Marwa Al-najjar
Associate Engineer, Planning Dept.
City of Albuquerque
Permit # BP 2023-04006
October 2, 2022

This letter shall serve as a clarification of the drawing comments from the TCL plan review for the Burger King Drive Through located on Lomas and Louisiana Blvd, in Albuquerque, NM.

TCL REVIEW COMMENTS from letter dated 05-16-2023 (numbers match comments listed on Case Comments Report):

DO NOT ENTER SIGN

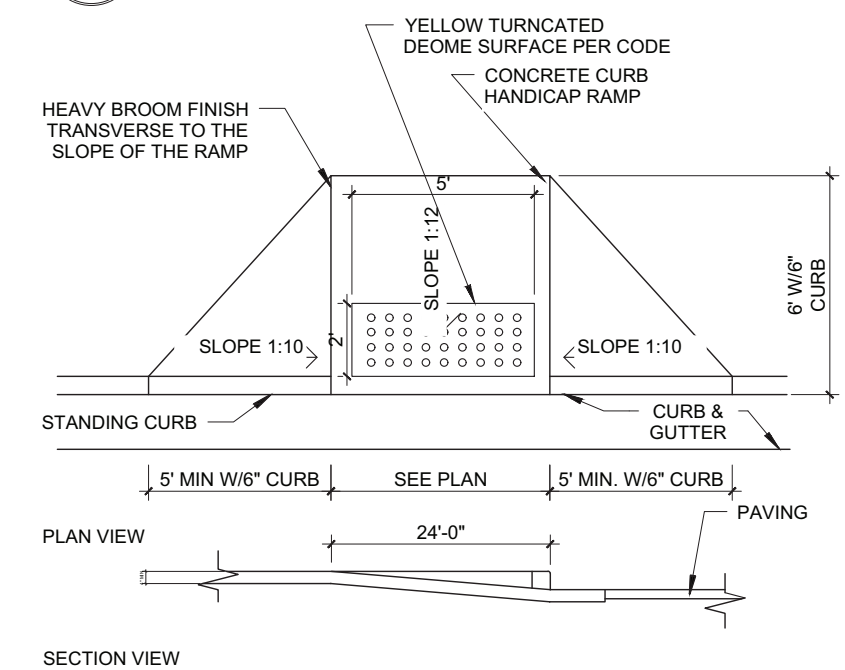
6. Please see attached TCL sheet- the "ONE WAY" lettering has been added to the pavement above the DO NOT ENTER lettering to address this issue.
 7. We have increased the width of the new drive through lane to 12'-0" as shown on the plans. The existing drive through lane is existing and is to remain.

TCL

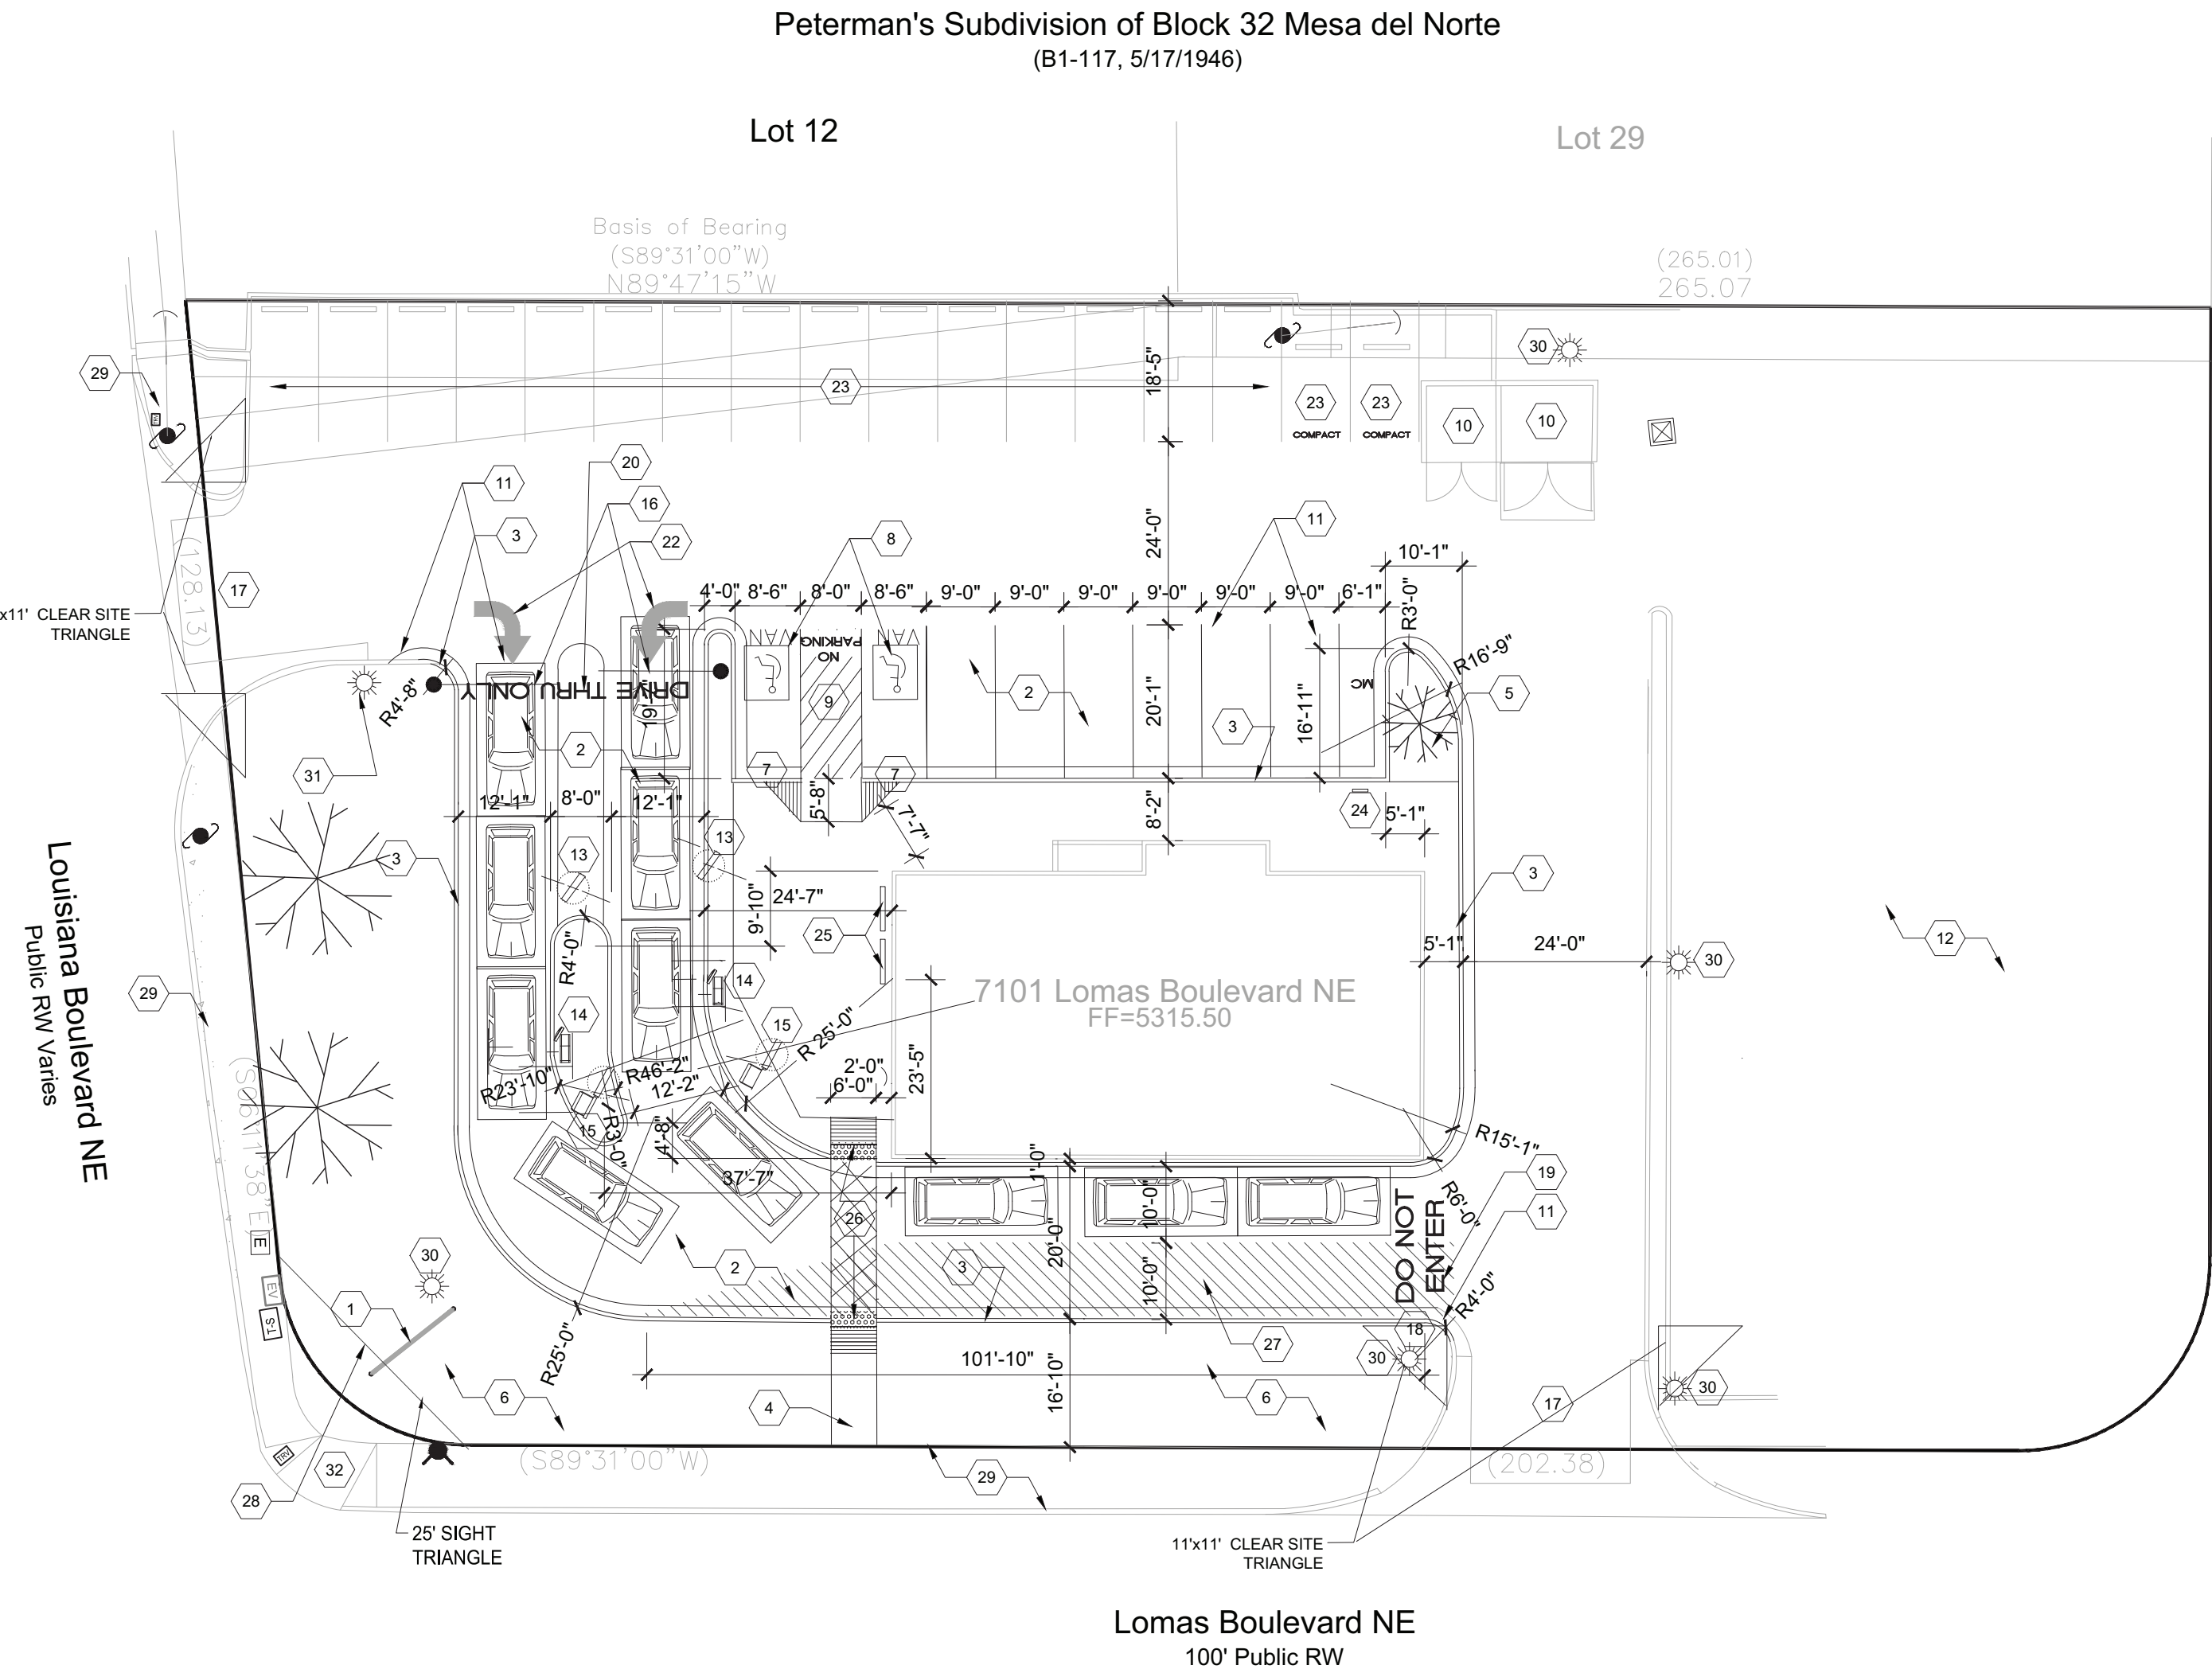
1. Please see revised TCL sheet attached which dimensions and clarifies the locations of these. There are only a couple along the north side.
 2. Please see attached TCL sheet- the dimensions have been added to the existing parking spaces along the north.

3. The plan design has been updated to include truncated dome mats to be installed at both driveway entrances. The drive pads are existing to remain and already follows the CABQ standard detailing for the ramping needs.

4. Please see attached TCL sheet- notes and a dotted line have been added to the existing layout plan to show the location of this pathway.
 5. The plan design has been updated to include a pair of concrete strips at the driveway entrance along Louisiana Blvd that are installed flush with the sidewalk that will allow the 4'-0" minimum clearance around the telephone pole to occur. The drive pad is existing to remain and already follows the CABQ standard detailing for this.

8. We are not planning any drive pad or city ROW improvements with this work as the drive pads all appear to be in compliance with the exception of the truncated dome mats (which we are adding per item #3 above).
